Application No: EP/16/21/PL
Site Address: Land East of 1 The Way East Preston BN16 1QJ
Description of works: Replacement garage. This site is in CIL Zone 4 (Zero Rated) as other development.

The committee agreed to raise the following objections to this Application.

Client: Mr D Lynch		
Project Address: The Garage The Way East Preston		
Drawing Title: Existing and Proposed Plans and Elevations		
Drawing Number: 1241.01.g		
Scale:	As stated printed @ A1	
Date:	06/01/2020

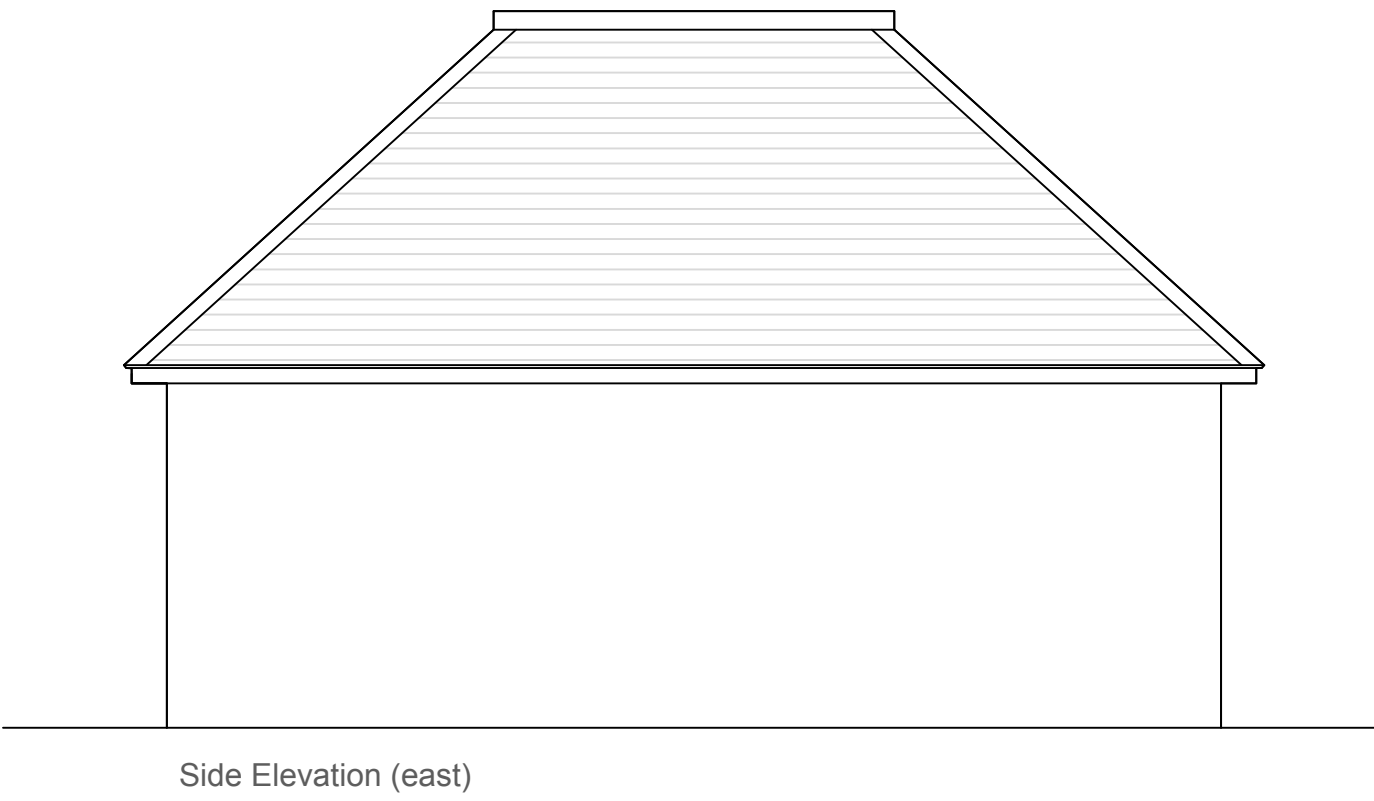
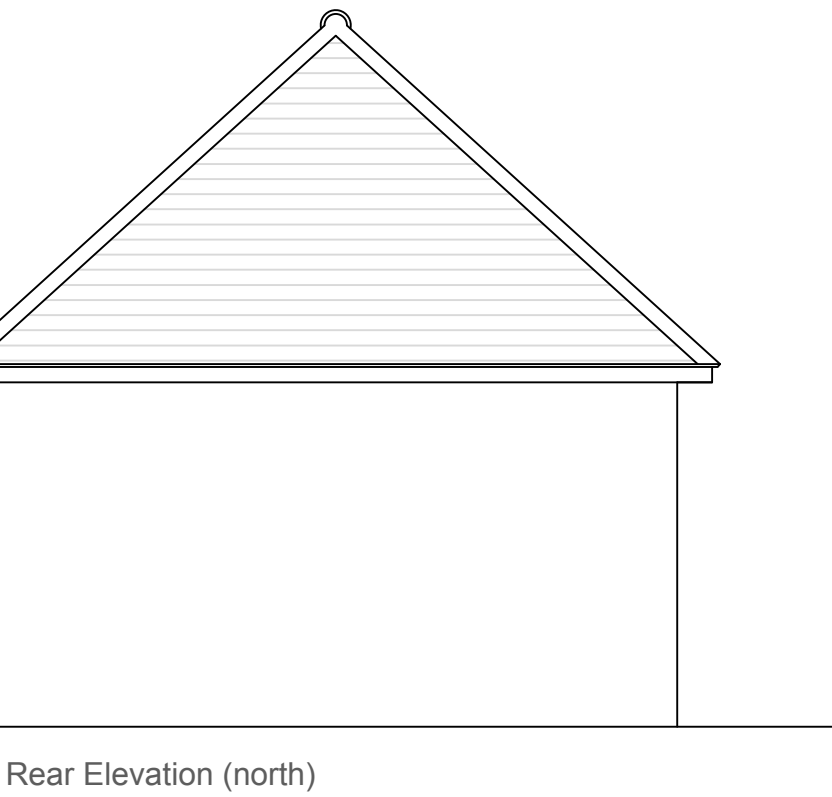
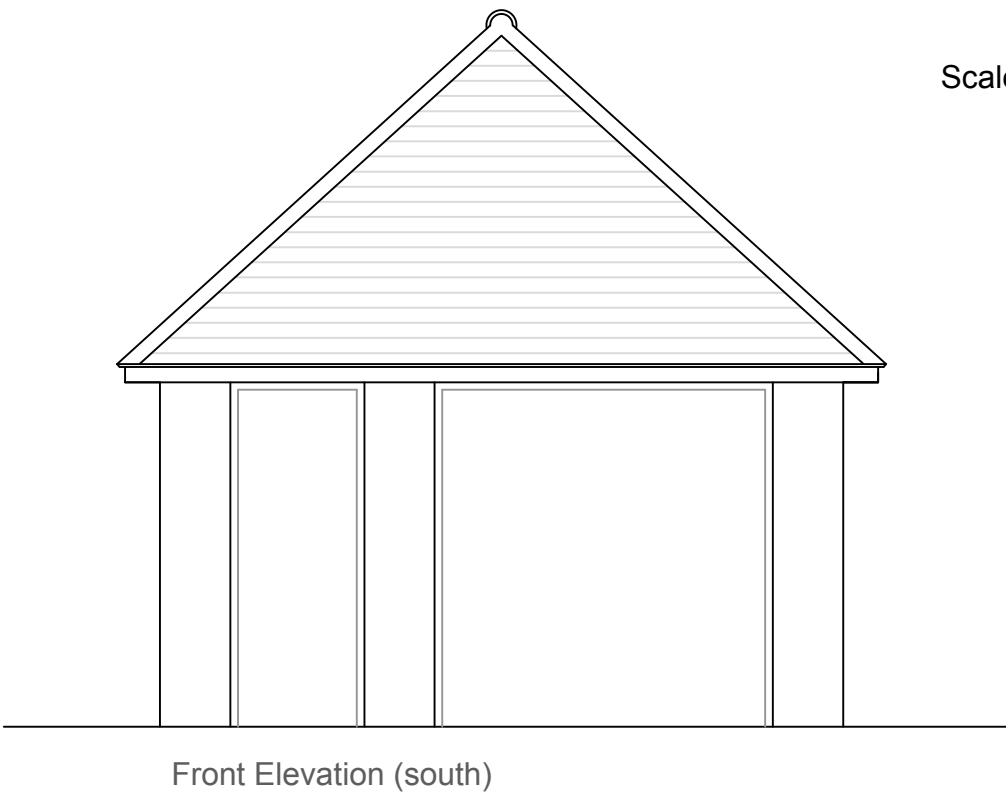
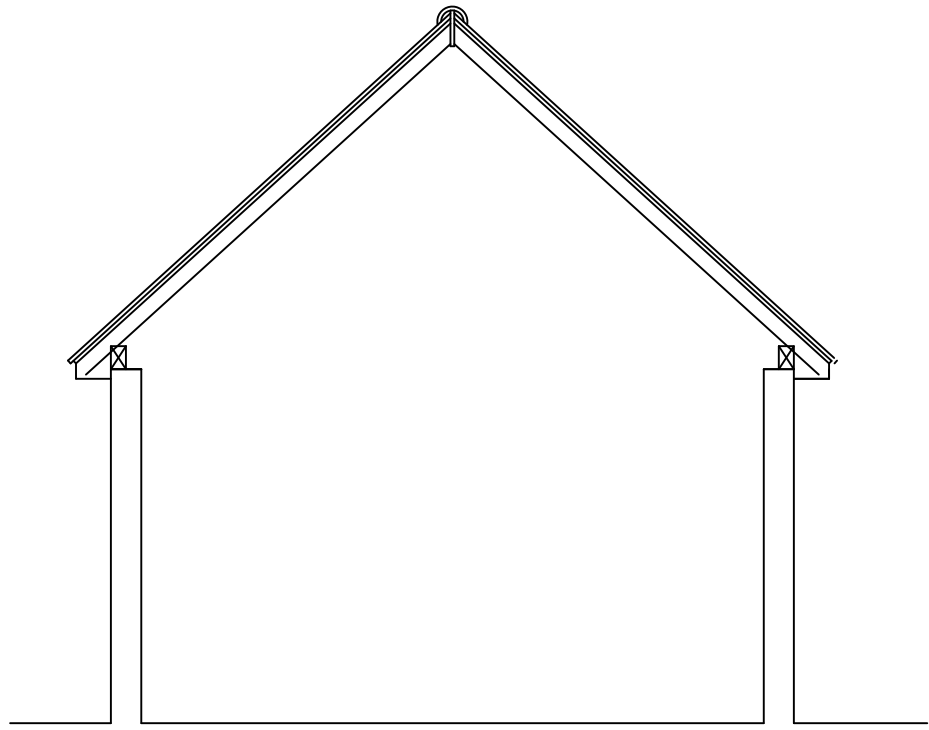
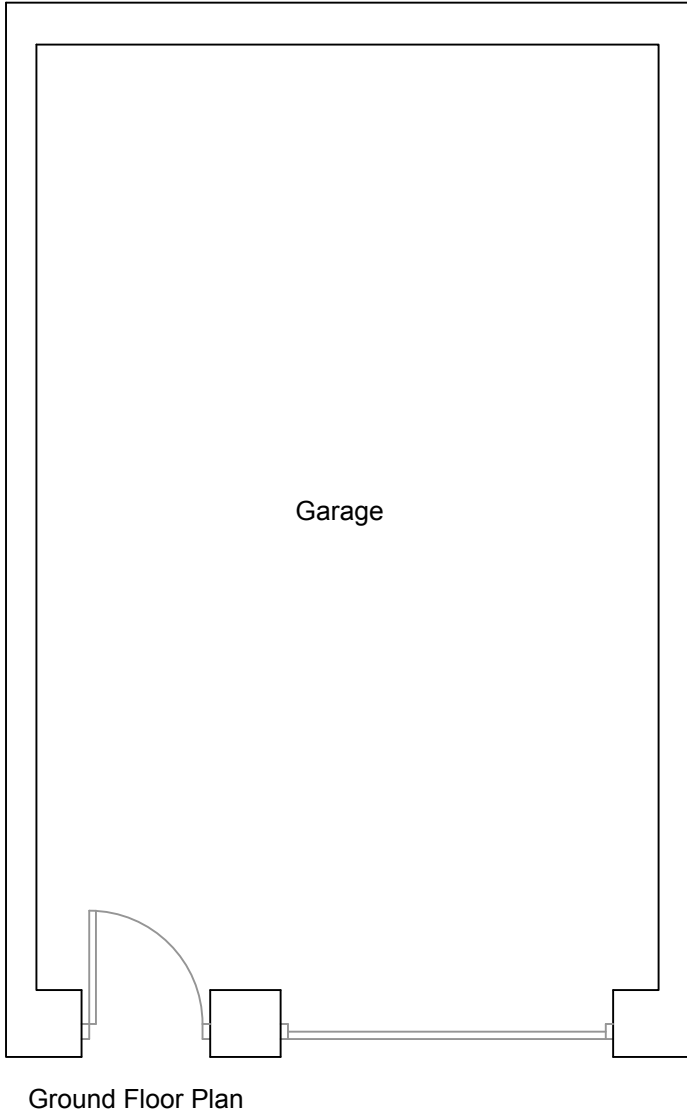
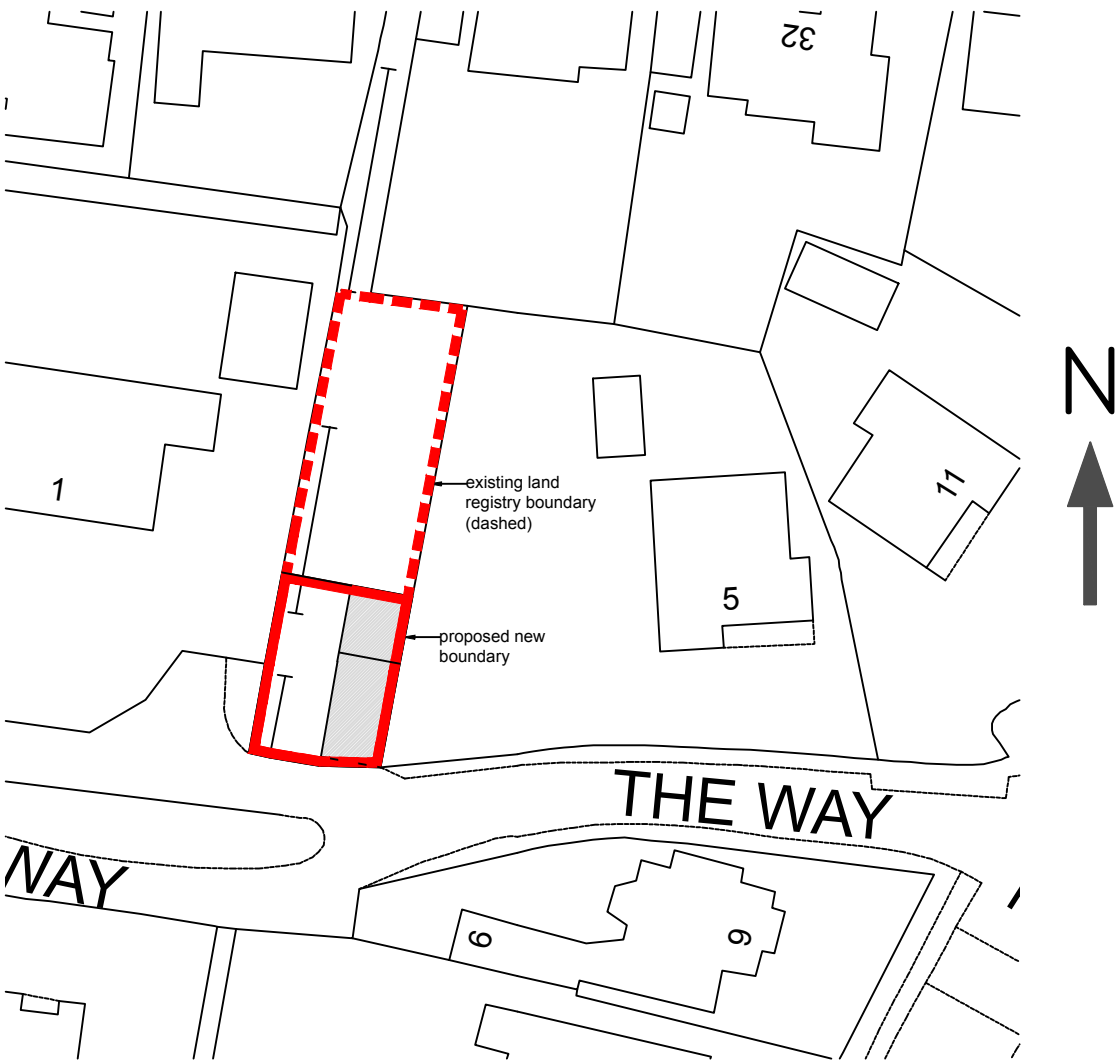
The proposed building sits right on the southern boundary of the plot. Furthermore, the building will lose its hip end and become a gable end. Although the proposed building is less than a metre taller than the existing building, this combination of location and design will, the council believes, result in a property noticeably more overbearing than its predecessor. The proposed height of the building is believed greater than the width of the road at this point.

The scale and mass of the proposed property will, this council believes, have an unacceptable impact upon the character and appearance of the immediate locality and residential amenities of the occupiers of neighbouring properties. This would be in conflict with policies D DM1 and D DM4 of the Arun Local Plan and Policies 1 and 3 of the East Preston Neighbourhood Plan.

The council felt the design conflicted with Policy 1 of the East Preston Neighbourhood Plan as the massing and height of the proposed building may not reflect and enhance the architectural and historic character and scale of the surrounding buildings. The proposal is particularly contrary to Policy 1, Paragraph 4.10 of the East Preston Neighbourhood Plan which states, It is important to avoid new buildings which appear overbearing by reason of their size, and alterations which harm the character of a road.

Noting the property would not meet current residential space standards, the committee also asked if a Condition preventing the upstairs from being converted into residential accommodation in the future could be considered.
